City of Portland, Maine - Building or Use Permit Application

Permit No: 05-1500	Issue Date: NOV 17 2005	CBL: 342 B031001
-----------------------	----------------------------	---------------------

Past Use: Vacant Lot	Proposed Use: Single Family Home/ Build a 26' x 36' Single Family Home	Permit Fee:	Cost of Work: \$125,000.00	CEO District: 5
Build a 26' x 36' Single Family Home		FIRE DEPT: <input type="checkbox"/> Approved <input checked="" type="checkbox"/> Denied <i>N/A</i>	INSPECTION: Use Group: <i>R-3</i> Type: <i>5B</i> <i>IRC 2003</i>	
		Signature:	Signature:	
PEDESTRIAN ACTIVITIES DISTRICT (P.A.D.)				
Action: <input type="checkbox"/> Approved <input type="checkbox"/> Approved w/Conditions <input type="checkbox"/> Denied				
		Signature:	Date:

FOUNDATION PLAN
 ROOF PLAN
 NOTES

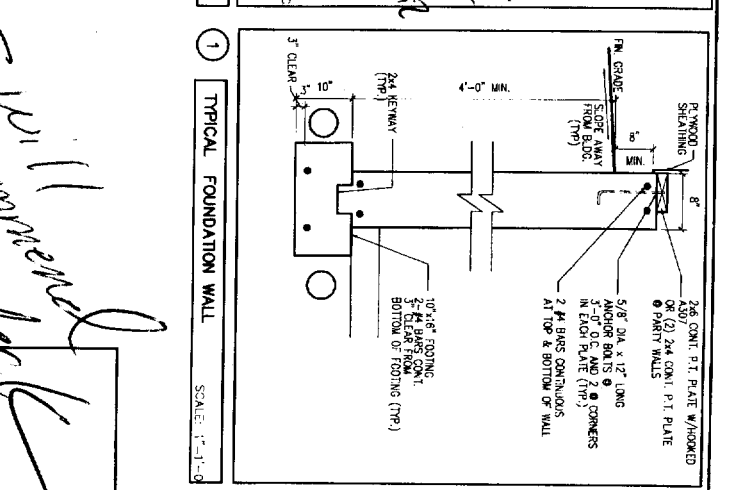
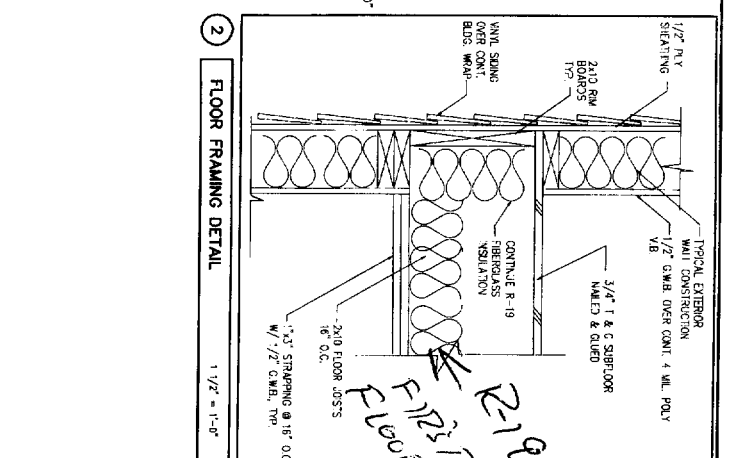
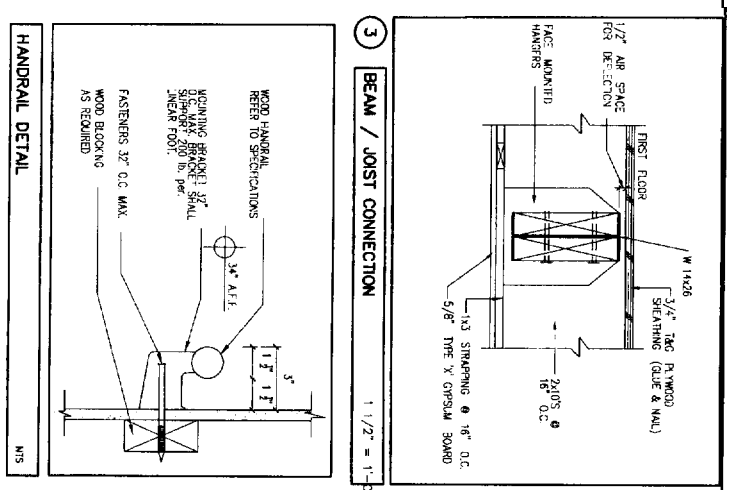
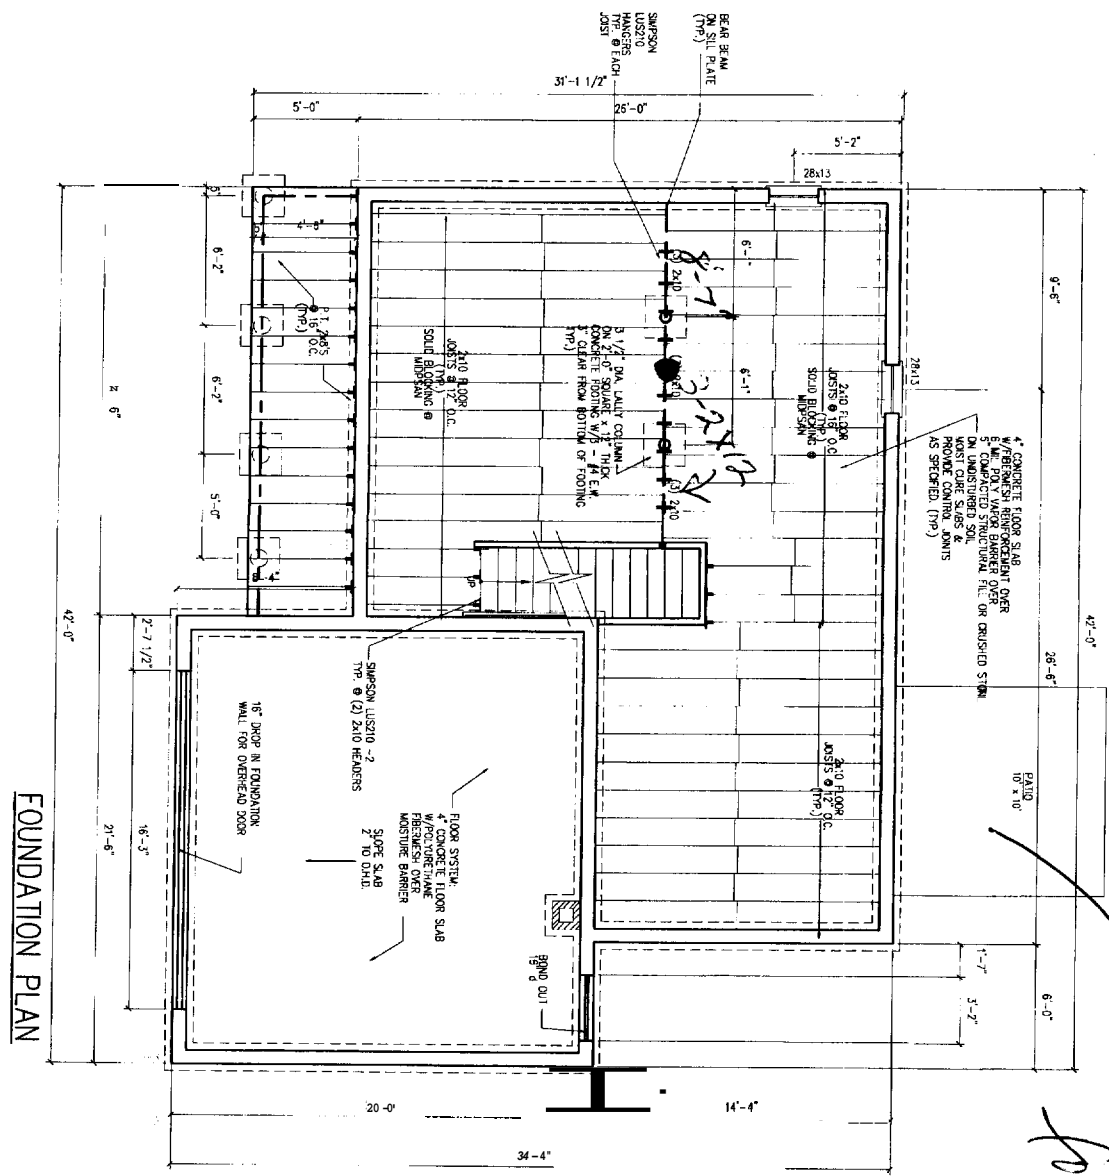
Need garage ~~cross~~ cross section ^{OK} or plan ^{OK} Cantilevered joists can only be 10"
 Need steel ~~engineering~~ engineering specs on beams
